Engineers Comments Regarding Surface Water Drainage

Application Reference:	R/93/25/DOC	Reviewer Reference:	ADC/EXT2/D2134/78
Planning Officer:	Simon Davis	Date of Review:	03.09.2025
Site Name:	Rustington Convalescent Home Sea Road Rustington BN16 2LZ		
Application Description:	Approval of details reserved by condition imposed under reference R/258/18/PL relating to condition number 19 - foul and surface water sewerage disposal.		
Assessment Number:	1 of 2

Condition 19: **Further information required**

DRAINAGE LAYOUT
SHEET 1 OF 3

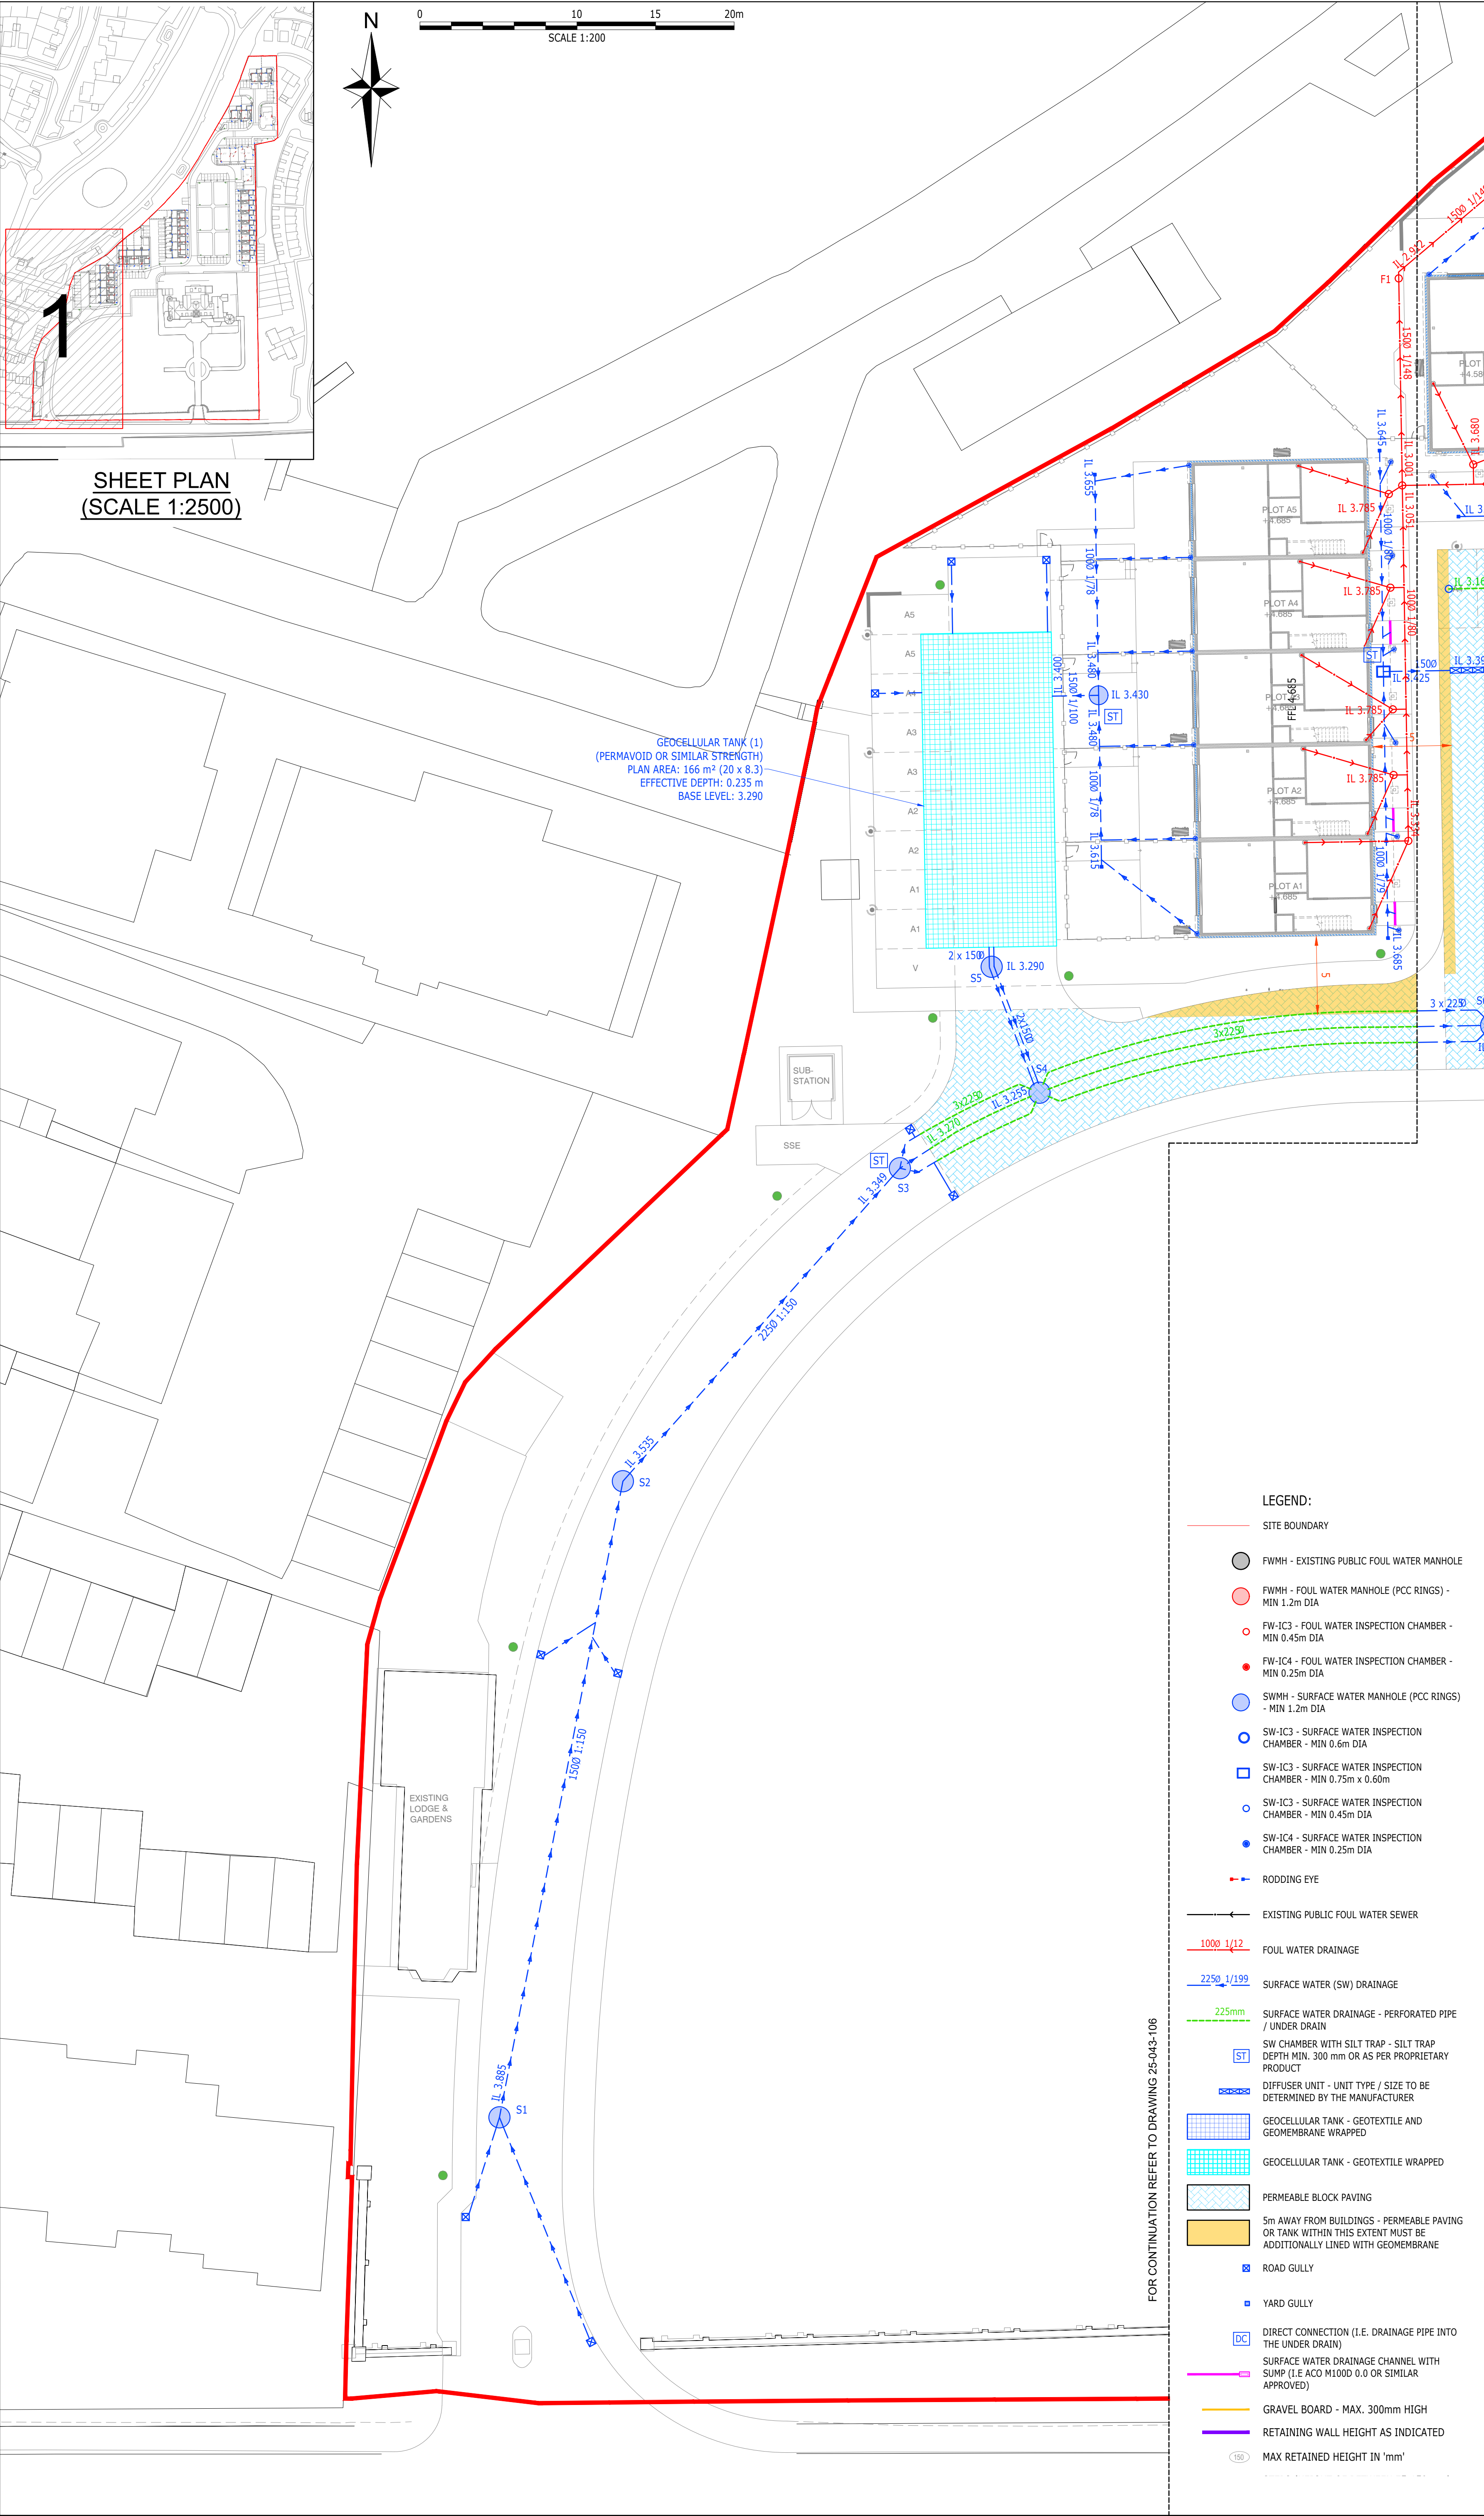
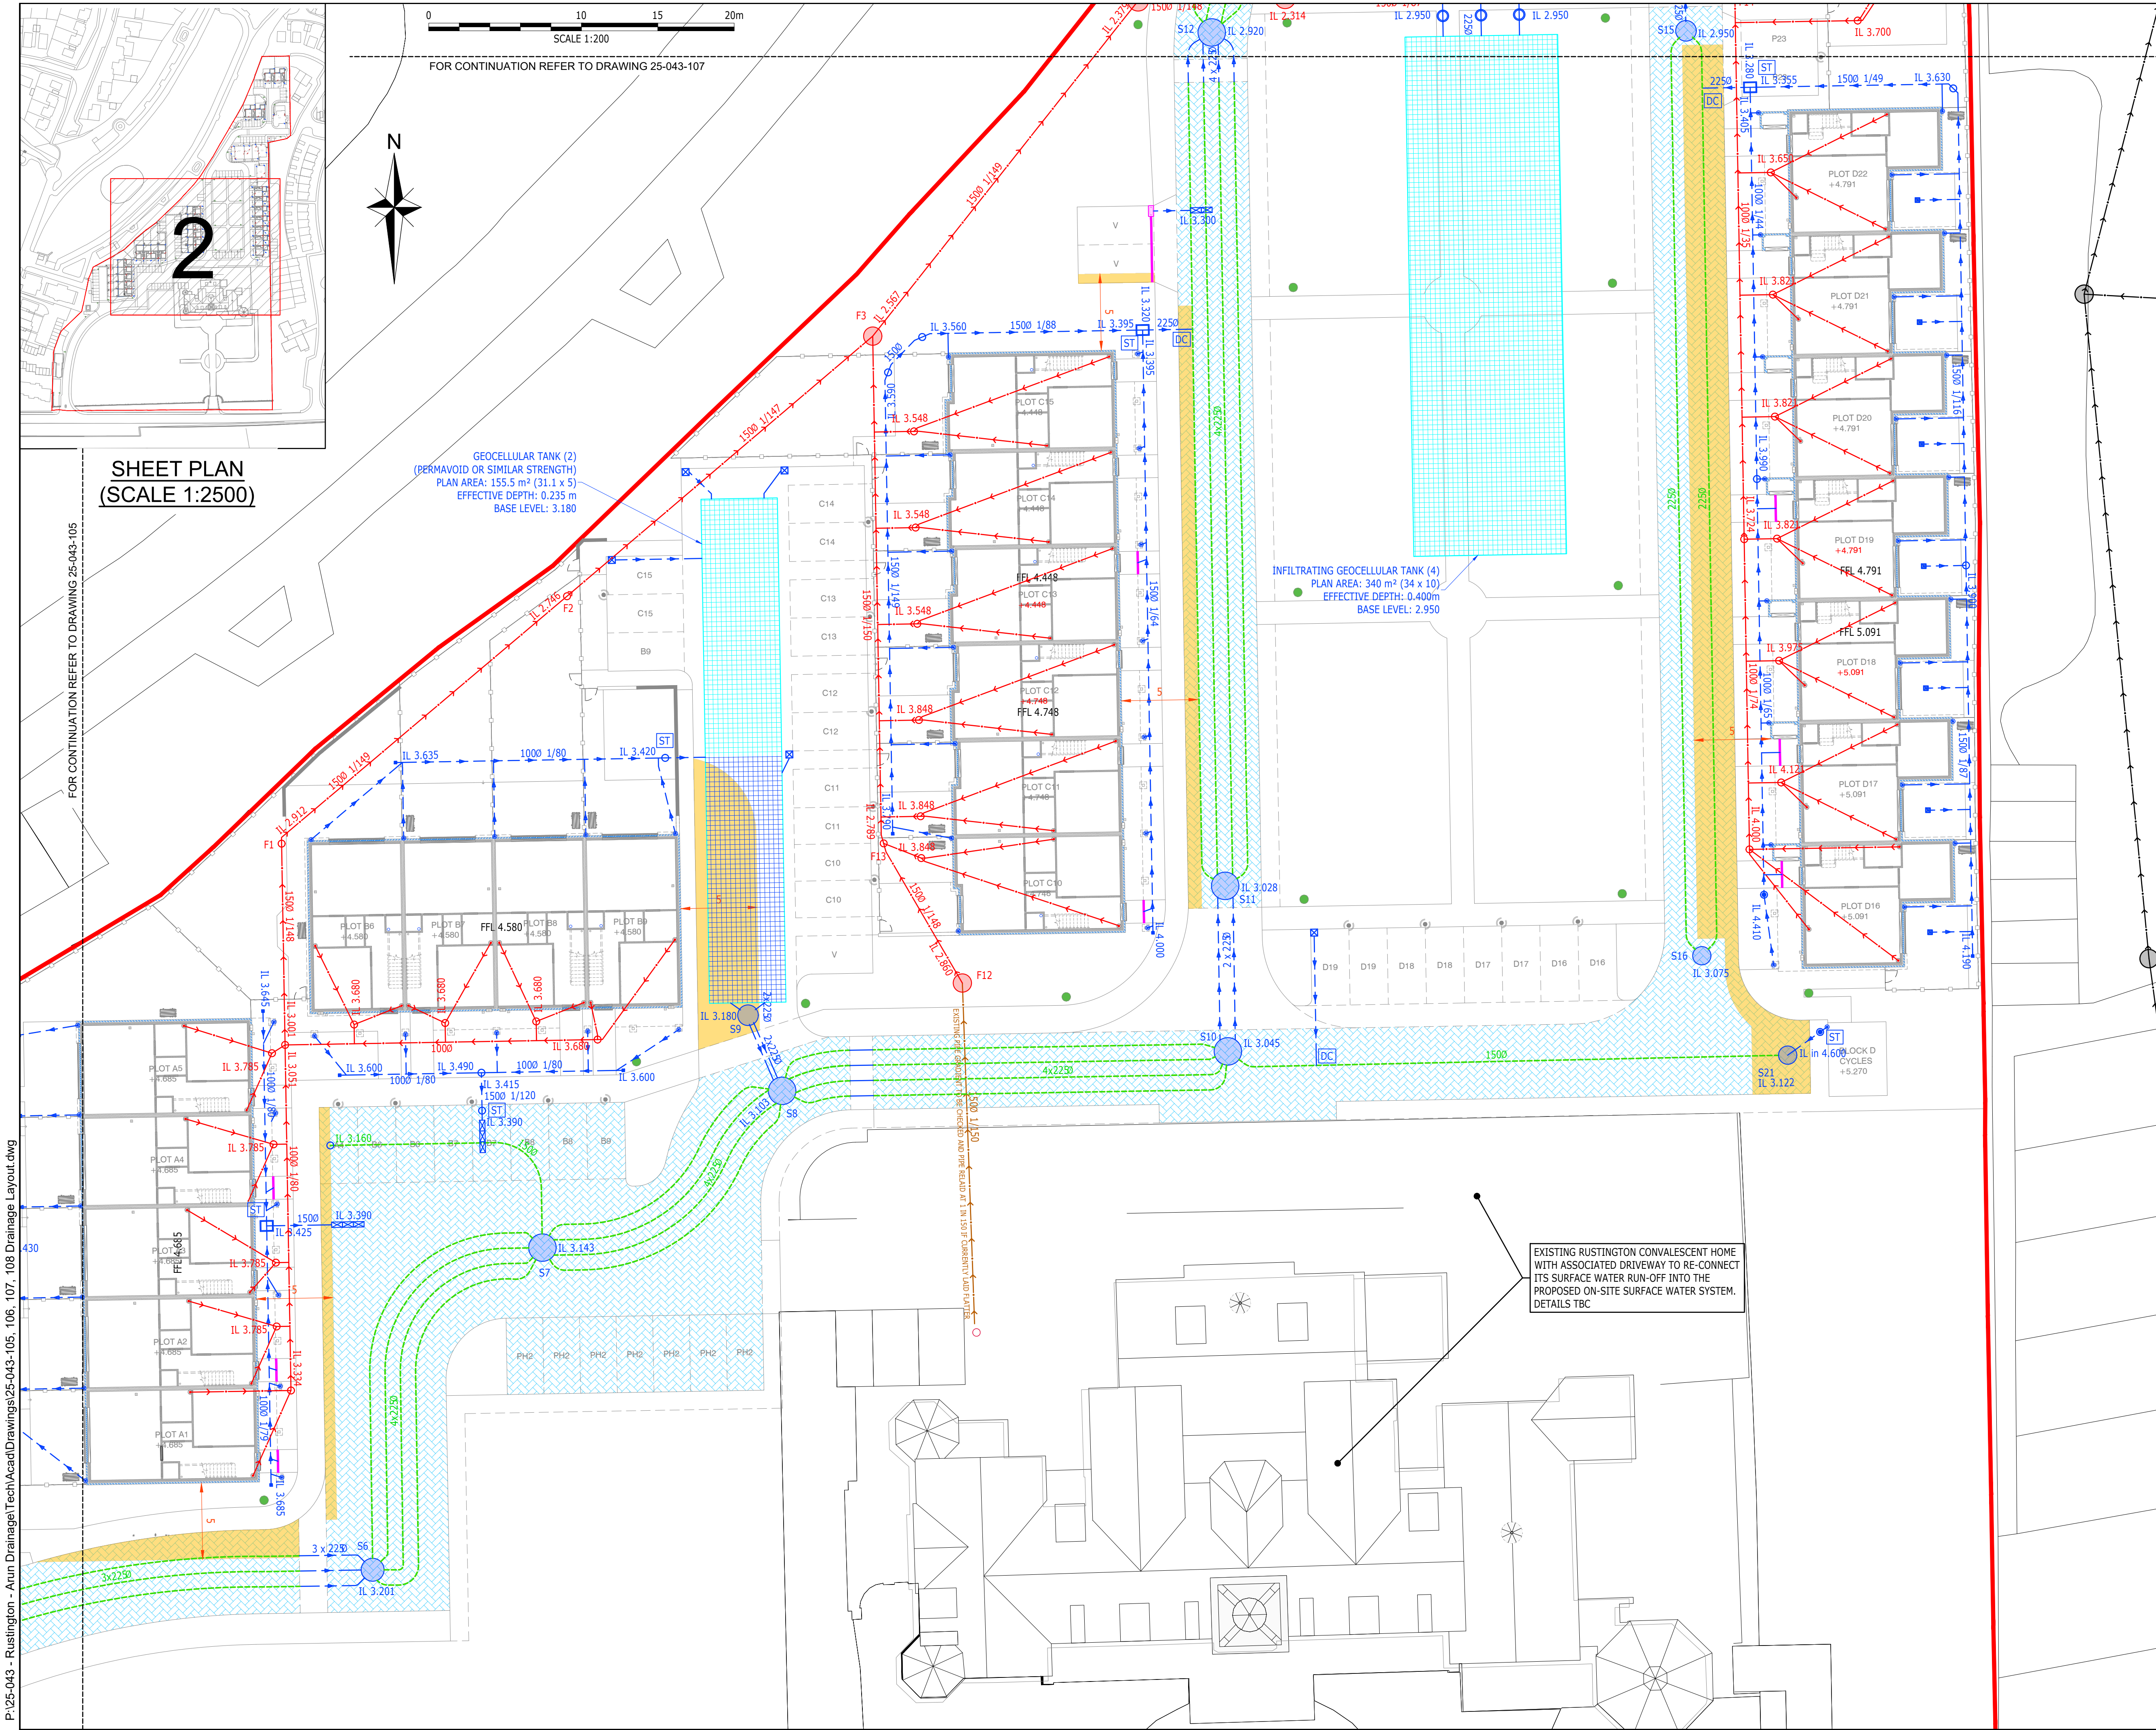
It is noted that additional drawings 105,106,107,108 do provide a fuller civils package including road levels, drainage, however the full site design is still missing in terms of level design coverage. Comment outstanding.

Drainage strategy drawings 1,2,3 do not include any reference to groundwater and freeboard to all SUDS features. Comment outstanding. Designer Response 18/08/2024: Please see Odyssey drawings 24-059-105, 106 and 107 which indicate the location of groundwater (GW) monitoring locations and highest recorded level. Proposed infiltration features have their base level located above the highest recorded GW levels at the appropriate locations. ADC Drainage Comments 28/10/2025: No further evidence has been provided in respect of groundwater and the response to this comment is inadequate. Whilst drainage layout drawings 105,106,107,108 annotate all geotechnical testing locations with groundwater levels, however numerous permeable pavement depths appears to sit below the peak groundwater datum. It is evident there does not appear to be any freeboard between any SUDS feature 'base' and 'peak GW' and the permeable pavement depths are variable. It remains unclear if the designer has made allowances for saturated storage. Comment outstanding.

A subsequent drainage statement has been prepared by GTA, dated 16th February 2022 which is understood to be the current report. Designer Response 25/06/2024: Refer to drawings:- - Drawing 24-059-SK005 – Surface Water Drainage Strategy Sheet 1 of 3. - Drawing 24-059-SK006 – Surface Water Drainage Strategy Sheet 2 of 3. - Drawing 24-059-SK007 – Surface Water Drainage Strategy Sheet 3 of 3. Associated calculation also included. ADC Drainage Comments 31/07/2024: These drawings are badged 'SK' inferring this is not a detailed design for construction purposes, as is required for a DOC discharge. These 'strategy' drawings cover high level and not detail, i.e. missing foul design, no FFL's, spots levels, gradients, low points, etc. Therefore we would expect supporting drawings for a full civils package including levels, drainage, surface finishes. Comment outstanding. Designer Response 18/08/2024: Please see the Odyssey drawings 24-059-105, 106 and 107 which indicate all drainage details requested. ADC Drainage Comments 28/10/2025: These drawings are still not sufficient for construction purposes, as is required for a DOC discharge.	levels from drainage drawings 25-043-105 to 107 as to avoid placing too much detail and information that would make actual drainage aspects less visible. We have however created drawing 25-043-108 which is showing drainage overall plan with detailed levels added.
